Recommendation Report for Planning Permission for Works or Extension to a Dwelling

REF NO: EP/18/19/HH

LOCATION: 21 Warren Crescent
East Preston
BN16 1BH

PROPOSAL: Single storey rear extension

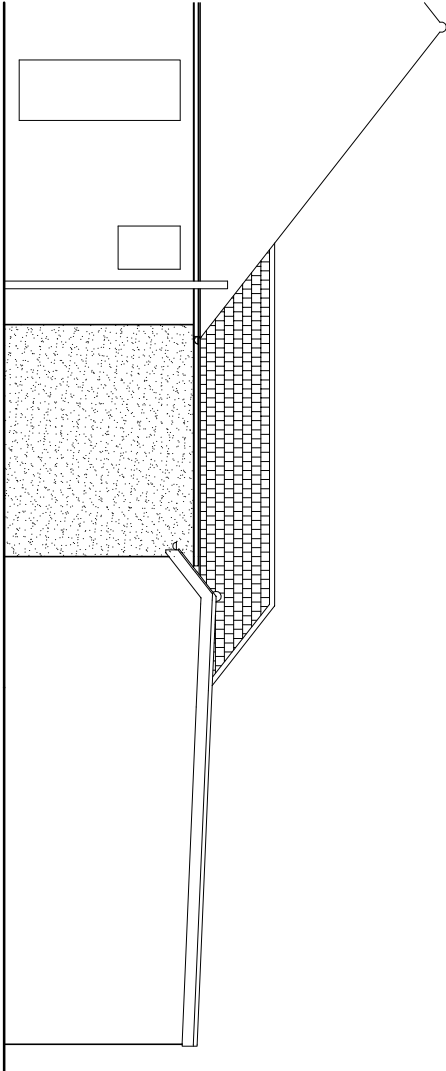
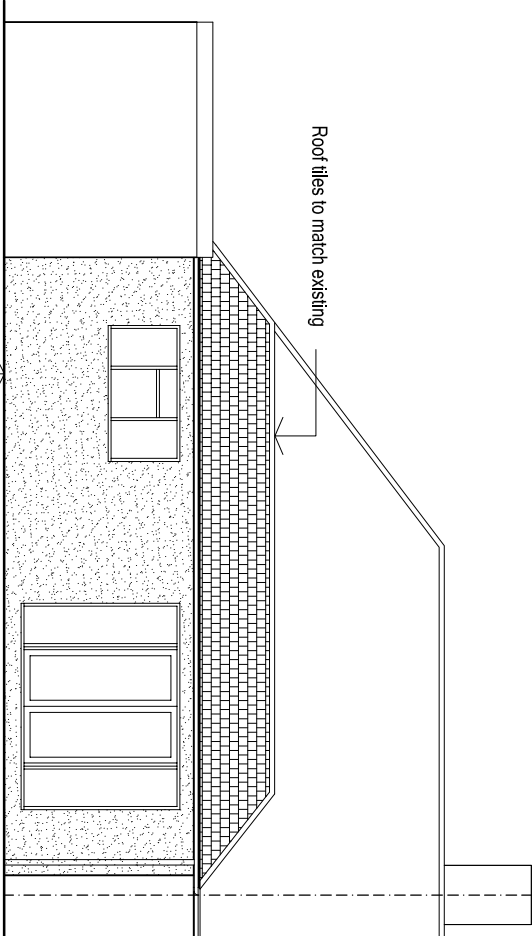
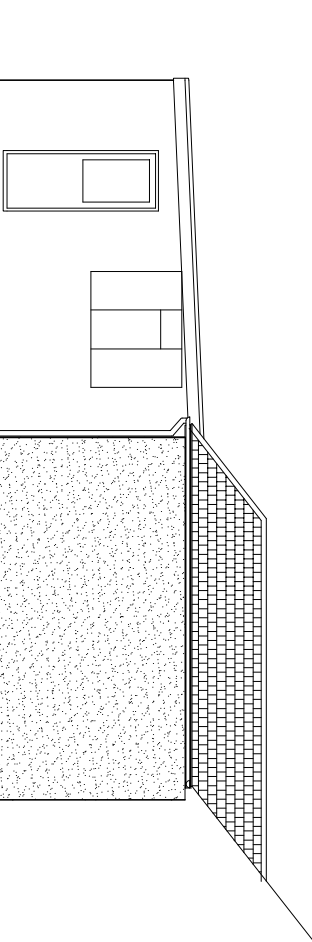
The proposed rear extension will measure approximately 4.8m in length, 8.1m in width and be built to a height of 3.1m. There is already an existing extension at the rear of the dwelling and that will be incorporated within the measurements provided for the proposed extension. The existing extension currently measures 3m in length, the proposed extension measures 4.8m in length, therefore the increase will be 1.8m.

In this instance the mid-point has been taken from the neighbour's window nearest to the shared Western boundary and the proposed extension would likely not accord with this rule. However, given the eaves height of the proposal would be approximately 2.5m, with the roof sloping away from the boundary it is considered that the proposed development will not result in unacceptably adverse impacts upon the residential amenity of 19 Warren Crescent.

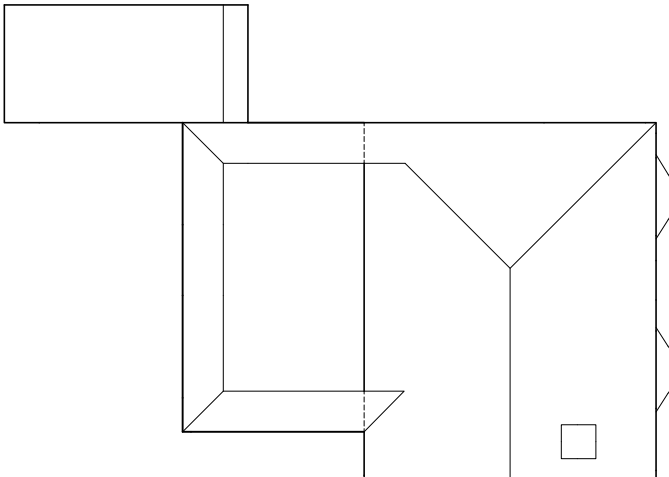
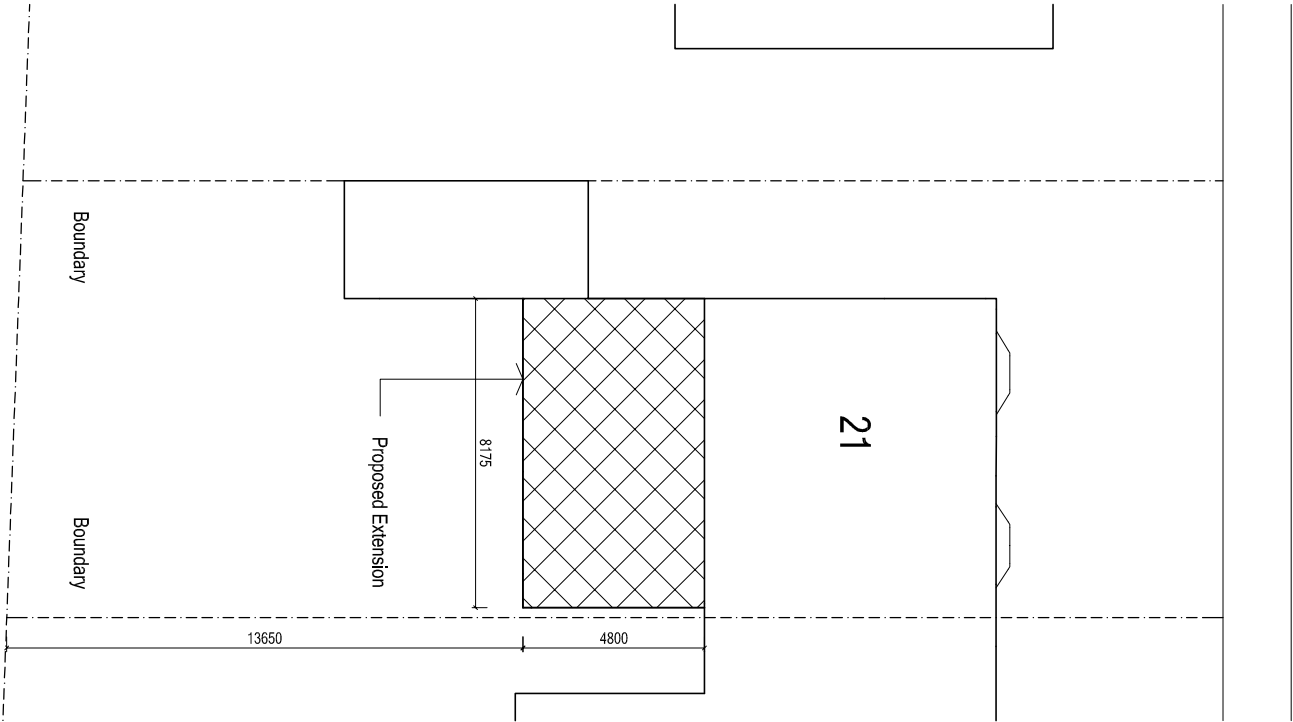
The proposed rear extension will be located approximately 0.1m from the Western boundary, 2.6m from the Eastern boundary and 13.4m from the Northern boundary. The proposed extension will link the existing dwelling to the existing detached garage, the link will be formed with a proposed door on the Eastern boundary, there are no other proposed windows or doors on the Eastern boundary. The proposed extension will also feature 1No. window and a set of double doors with 2No. windows either side of the doors on the Northern boundary. Given the distance double doors and windows and the Northern boundary of the site is approximately 13.4m and will overlook the rear garden at ground floor level, they will not give rise to any additional overlooking or loss of privacy to the neighbouring properties. No windows have been incorporated on the Western elevation of the proposed extension to further mitigate any potential impact upon neighbouring properties.

The rear garden of the dwelling house lies adjacent to a railway line, if the proposed development falls within 10m of the railway there would be a requirement to consult with National Rail, however having measured from the drawings submitted there is a proposed distance of approximately 13.4m from the development to the Northern boundary and therefore is deemed that this consultation is therefore not required.
